Your Ref: OWPC18018
Our Ref: A/36/18/OUT 12-03-2018
Please ask for:
Mrs A Gardner

Outline planning application with some matters reserved for the erection of up to 200 dwellings with access, public open space, landscaping and sustainable drainage system (SuDS) with vehicular access point from Arundel Road, one full-sized adult football pitch and the demolition of industrial units and one residential dwelling. Departure from the Development Plan.

Land off Arundel Road Angmering

Thank you for your internet representation made on 26th April 2018 which has been recorded as '**an objection**' with the comments as follows:

Figure 5.4: Proposed main vehicular access point off Arundel Road.

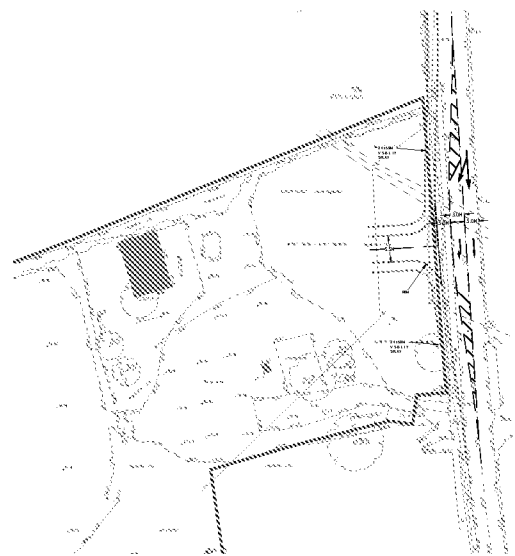
The safety audit included within the highway report has significant reservations regarding

the achievement of the visibility splays due to the incline of Arundel Road and refers to the stage 2 safety audit allowing for the provision of additional information, it would be prudent at this stage to request cross sections of the existing road with the new access point so this can be assessed in detail at this stage of the application.

The current position of the access road will have significant impact upon the existing property Wilmington and a better design solution could be found minimising the impact upon adjoining neighbours and improving highway safety.

The proposed access is within a 60MPH speed limit and therefore is it the intention of the applicant to seek a TRO to decrease the current speed limit and to restrict parking upon Arundel Road?
